From: Hugh Milner [REDACTED]
Sent: 22 October 2019 16:30
To: Andrew Wood <Andrew.Wood@arun.gov.uk>
Cc: Kate Giddings <kate.giddings@arun.gov.uk>; Rob McAlees [REDACTED] Steve Bates
[REDACTED] jaskew [REDACTED]
Subject: Re: LU/299/19/PL - Upgrade of football pitch floodlights at Littlehampton Town Football Club

LU/299/19/PL - Upgrade of football pitch floodlights at Littlehampton Town Football Club

PROPOSED LUX LEVELS

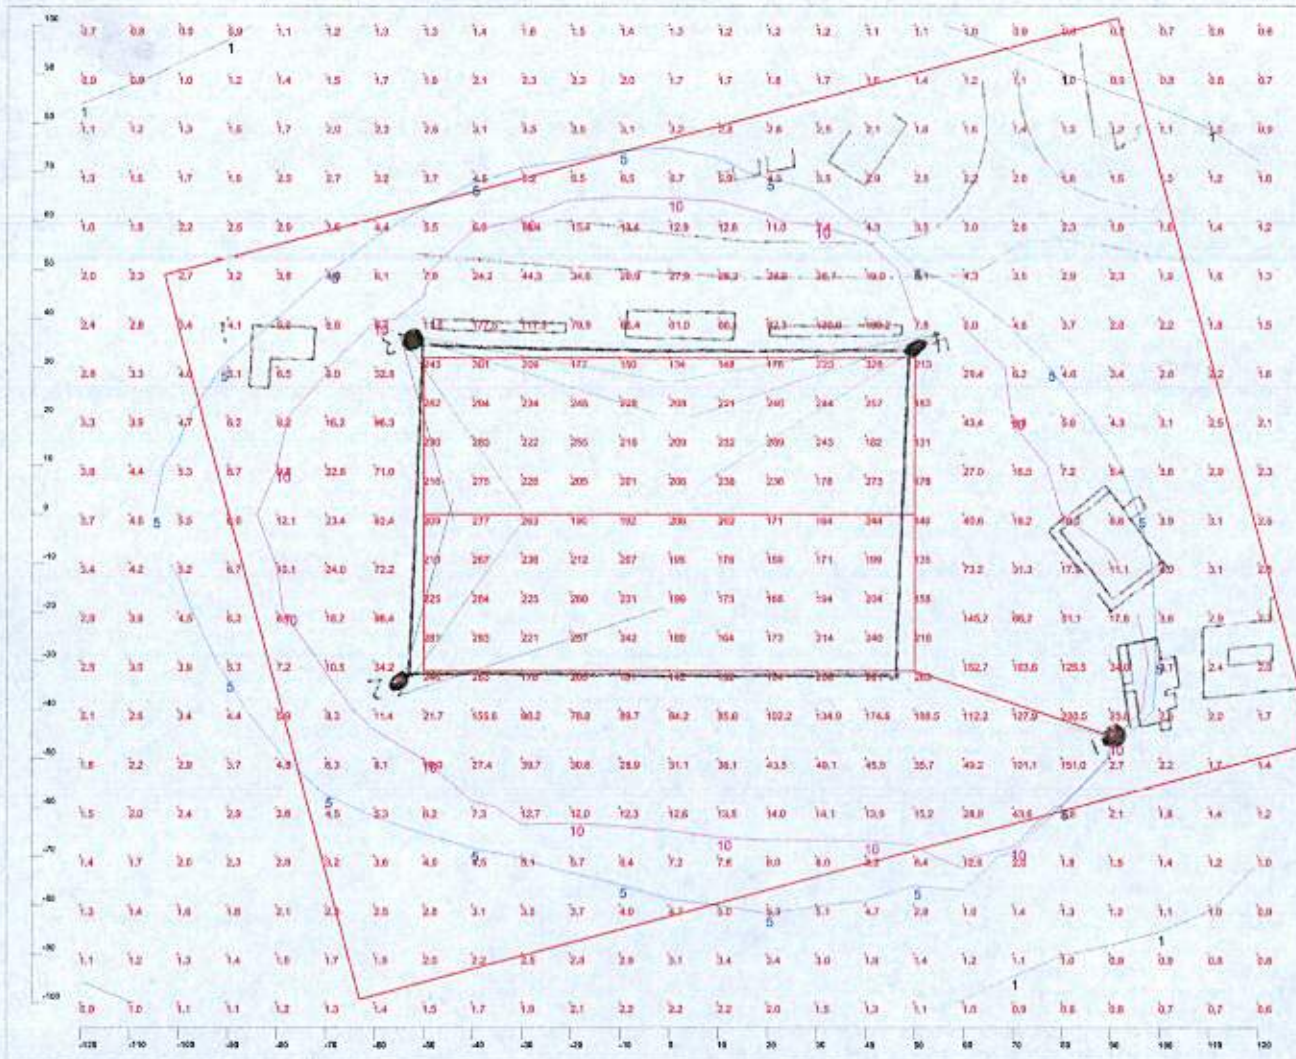
Attached to the planning application were two floodlighting survey charts that set out the maintained horizontal lux levels of the existing floodlighting configuration and the maintained horizontal lux levels of the proposed installation. The requirements of the Football Association state that the illumination levels shall be recorded on the horizontal plane at ground level, using a self levelling tripod not more than 12 inches above the ground. Readings are required to on a grid of 88 markings (8 across and 11 down) evenly spaced with the outside readings falling on the pitch boundary line. The average of all the readings is taken to be the average illumination level in lux of the floodlighting illumination.

Prior to construction, the horizontal luminance levels on the playing surface/arena shall be submitted to and approved in writing by the Local Planning Authority. The horizontal luminance levels shall be no greater than levels specified for the particular sport/activity and for the level of competition as specified within BS 12193:2018 'Light and Lighting – Sports Lighting'.
